**Addendum No. 1**

RE: Contract # C203987

**Durham County (B-4943)**

Bridge #20 Over Dial Creek On SR-1616

REVISIONS						SHEET NO.
NO.	BY:	DATE:	NO.	BY:	DATE:	S-1
1			3			TOTAL SHEETS
2			4			19

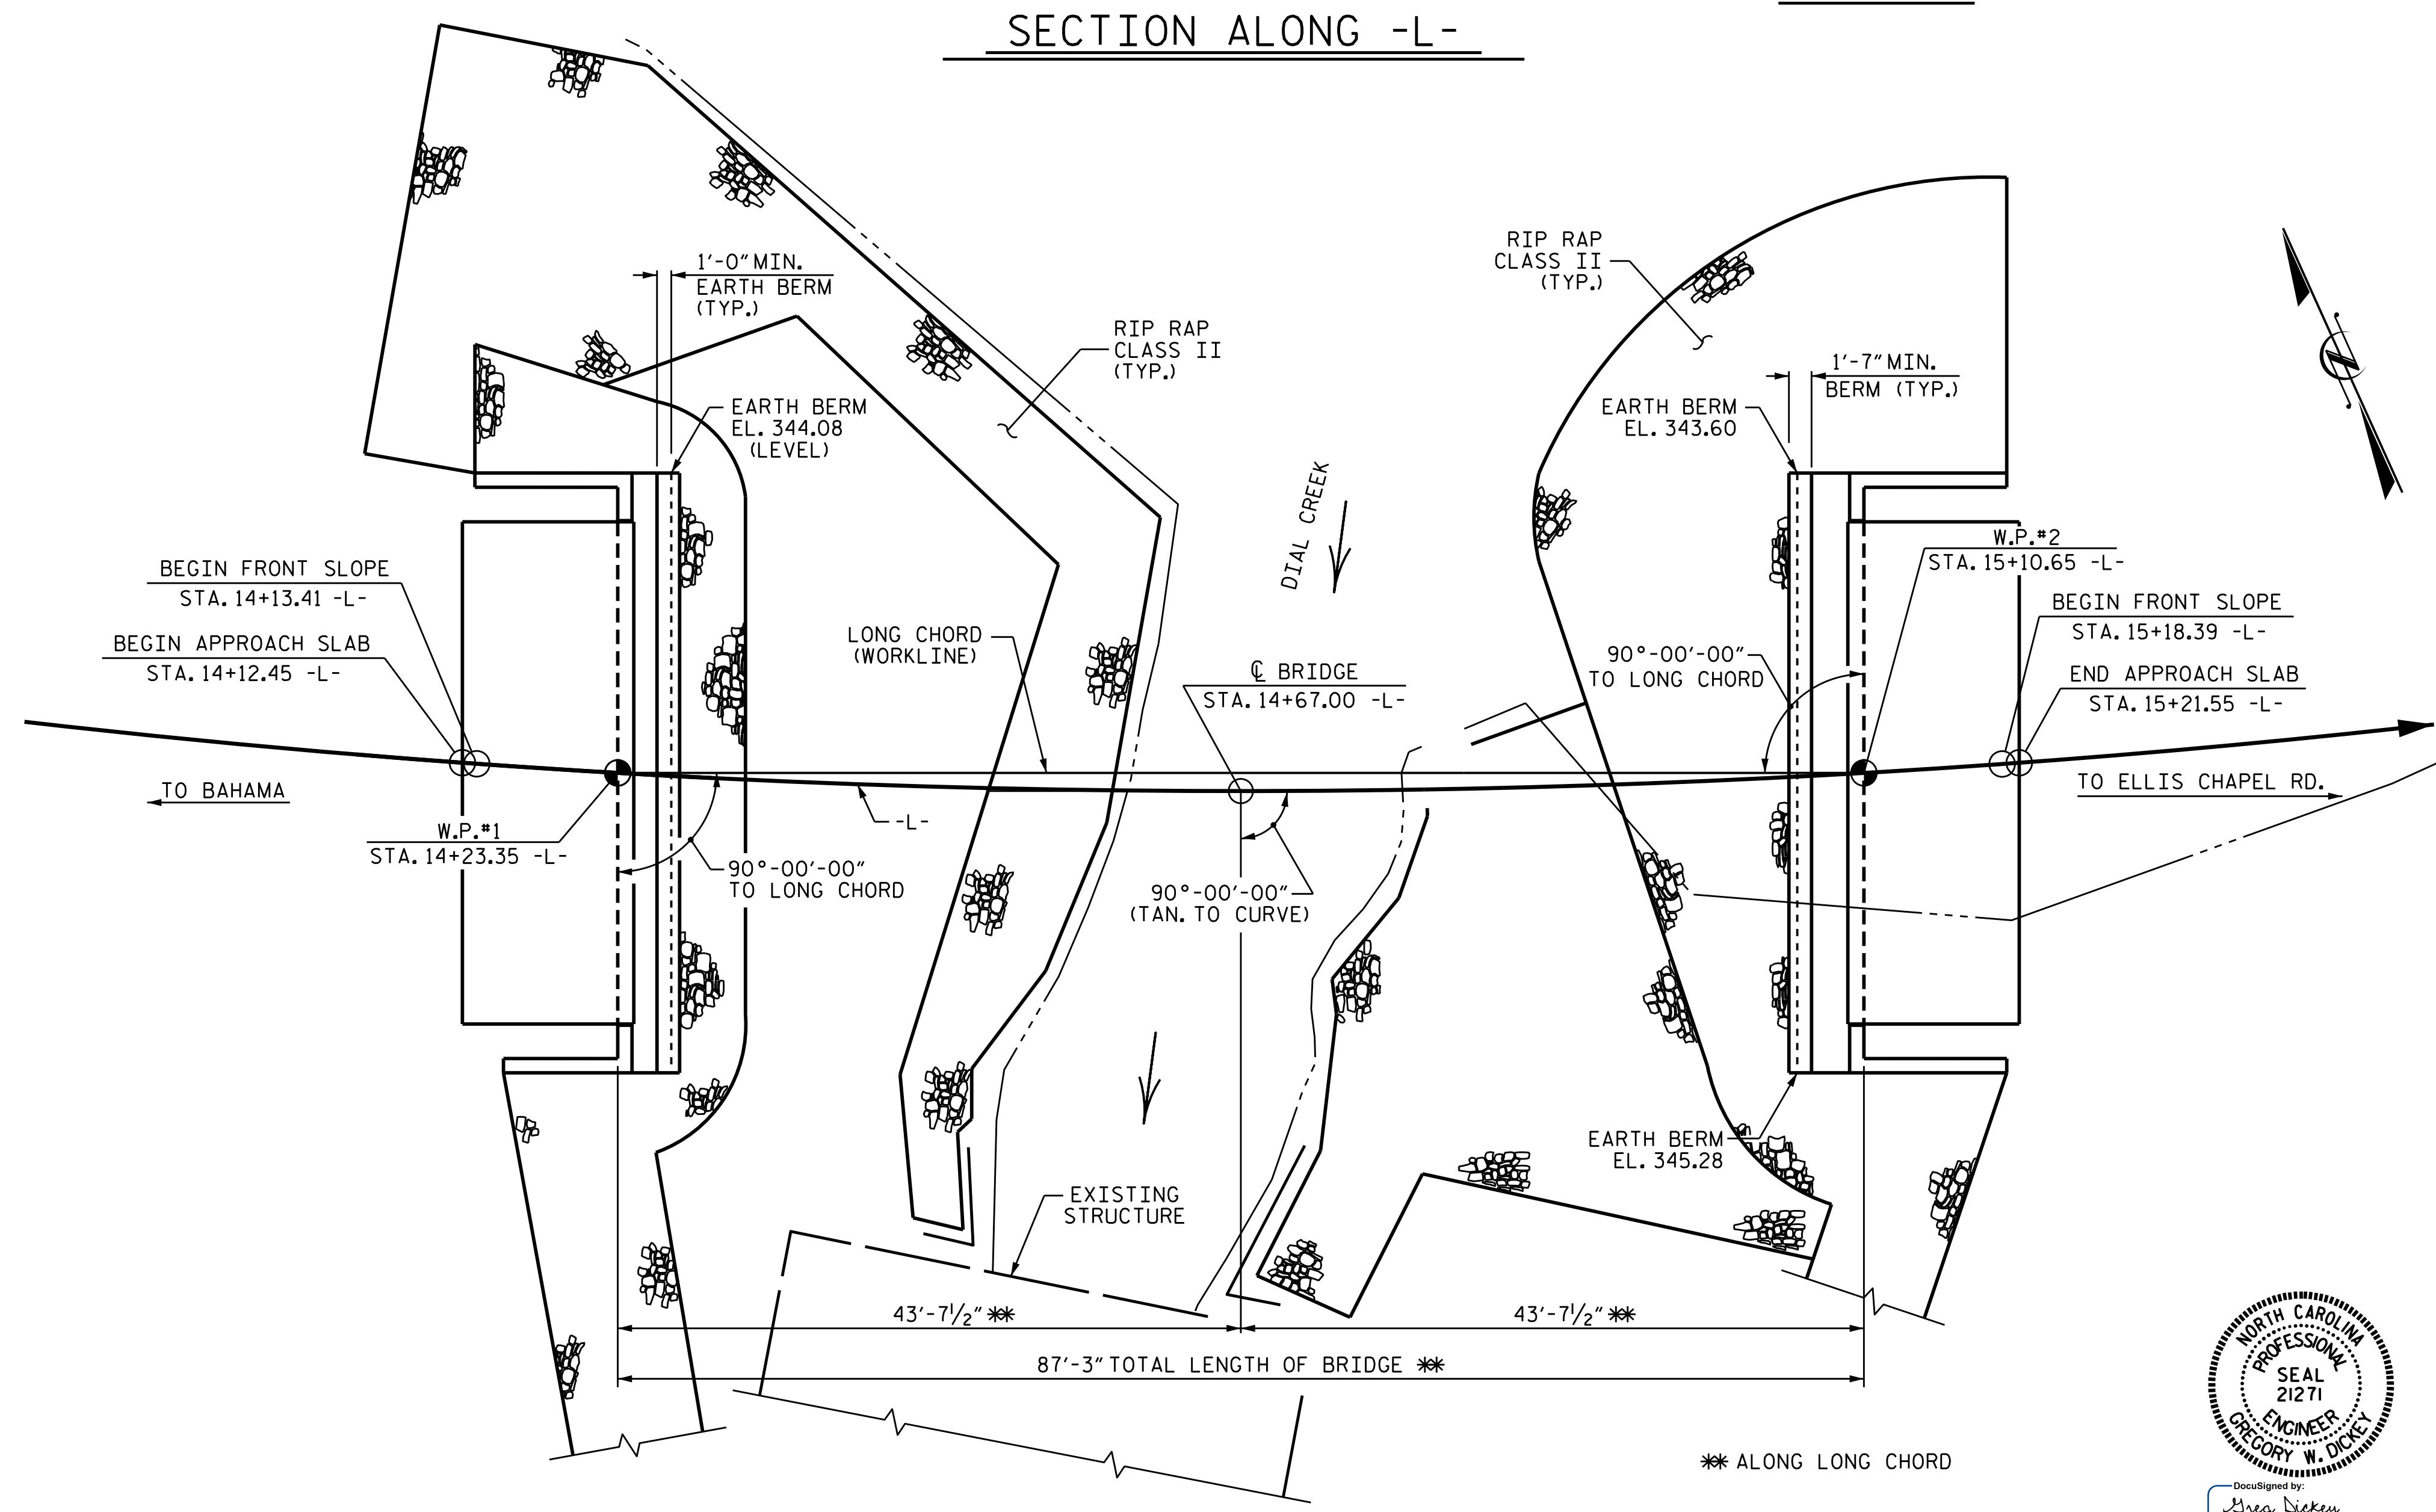
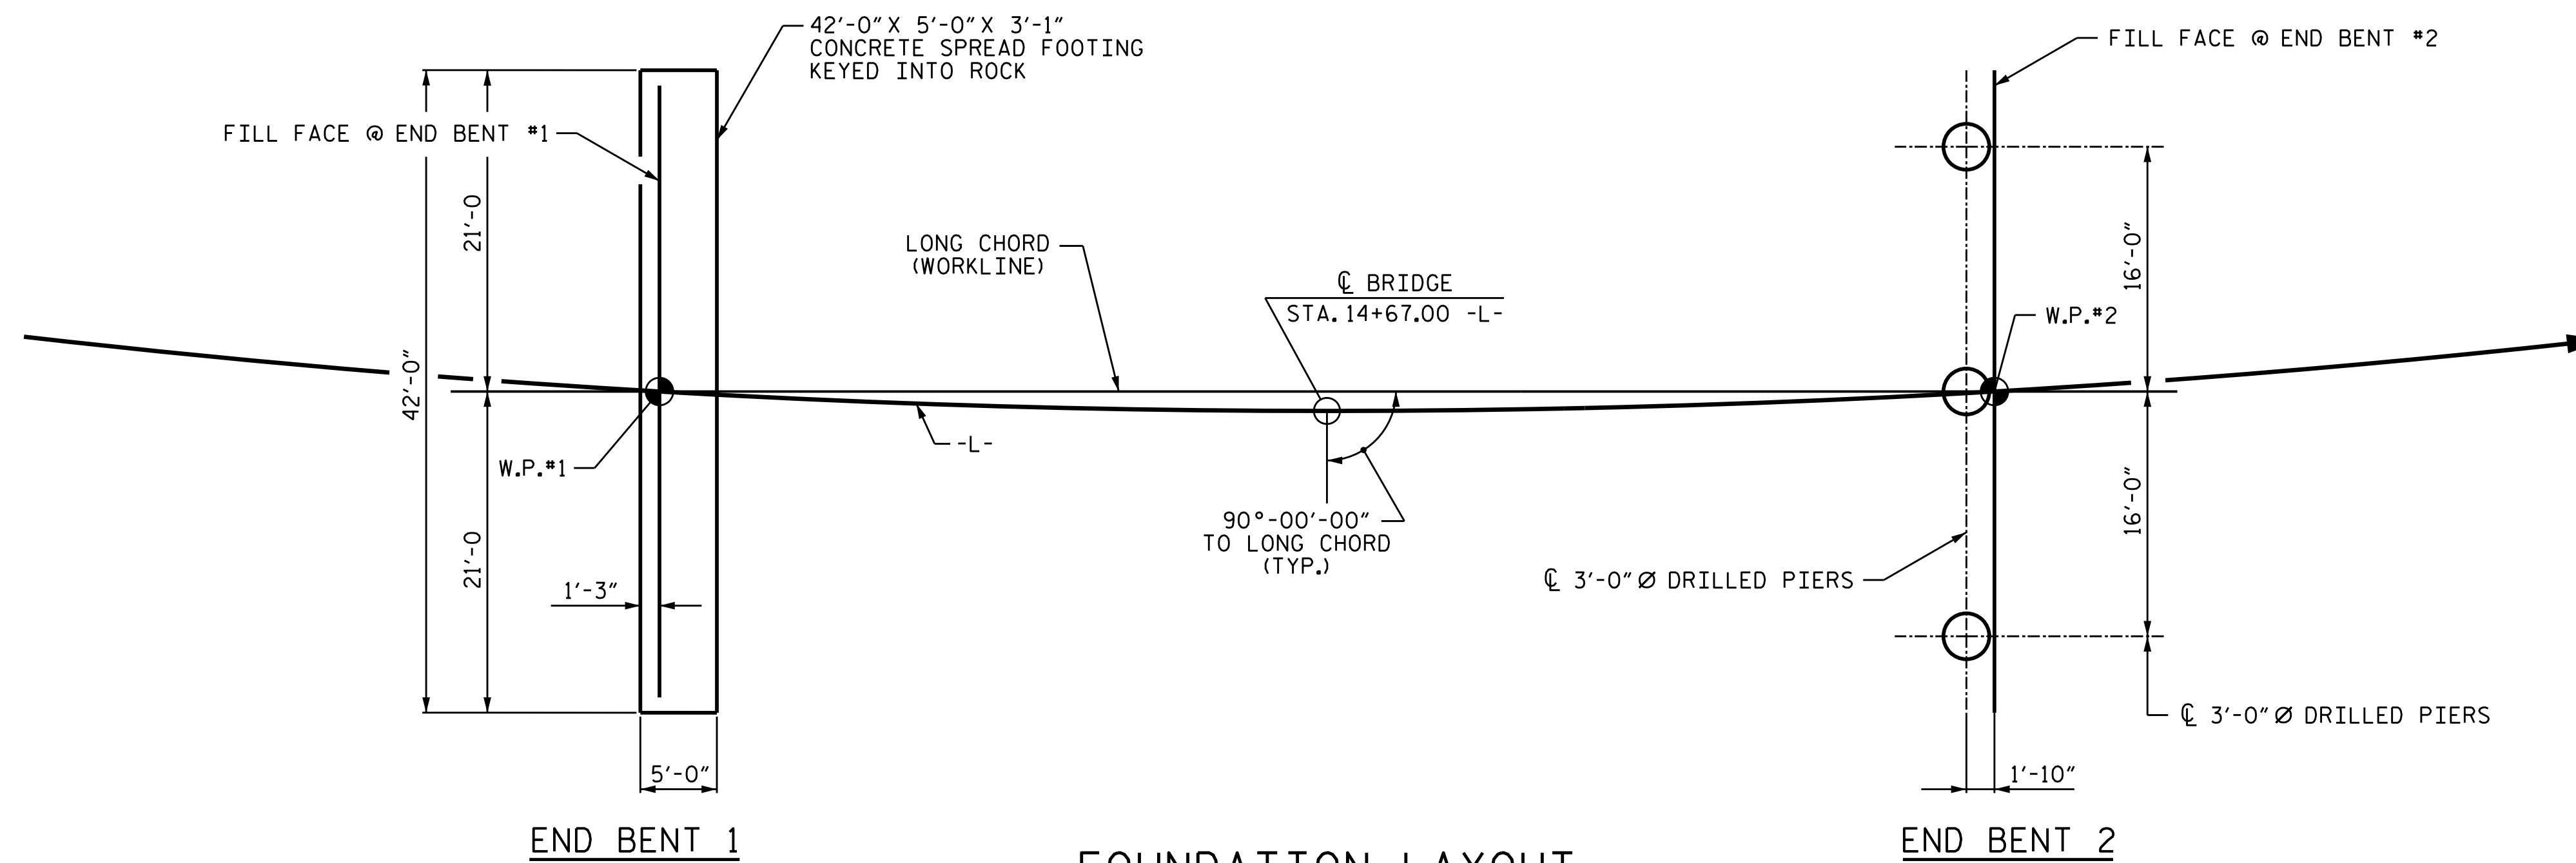
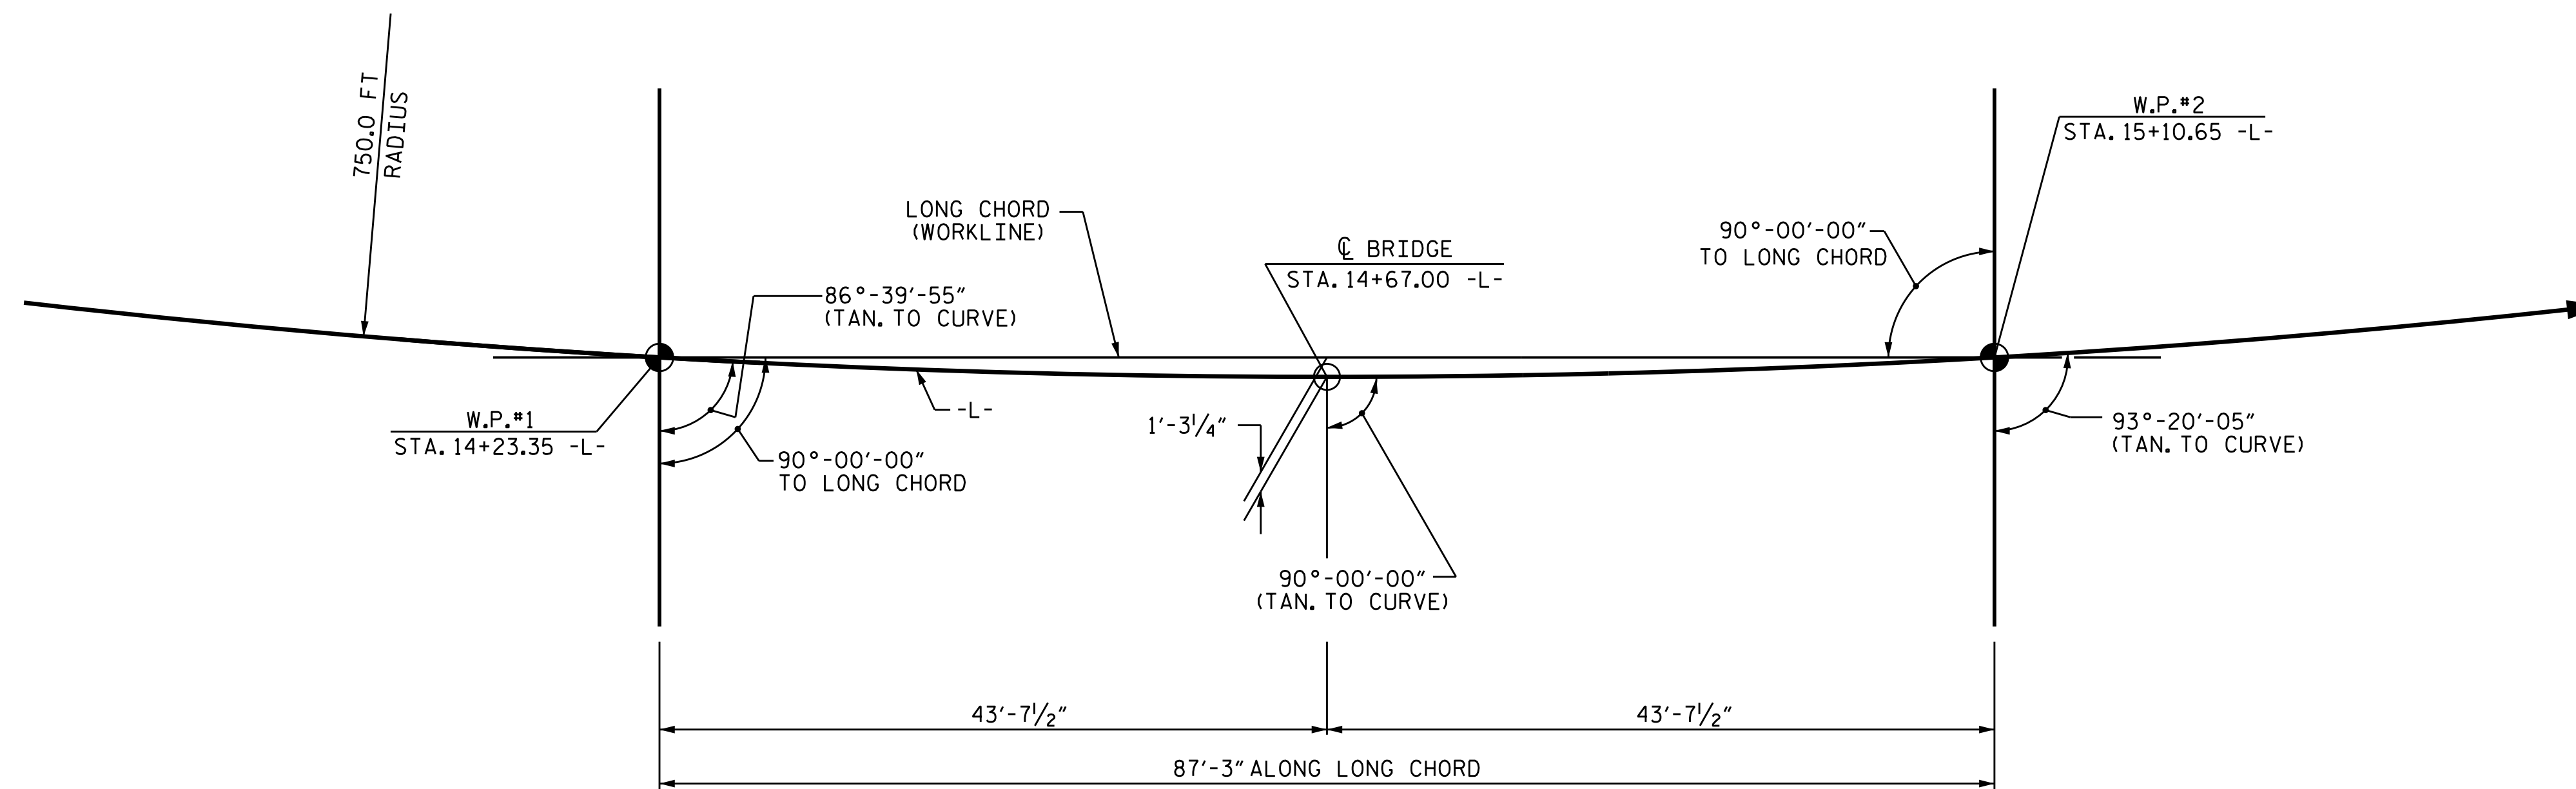
Sheet No.	Revisions
S-1	Revised to remove the Temporary Shoring
S-3	Revised to remove the note concerning Temporary Shoring
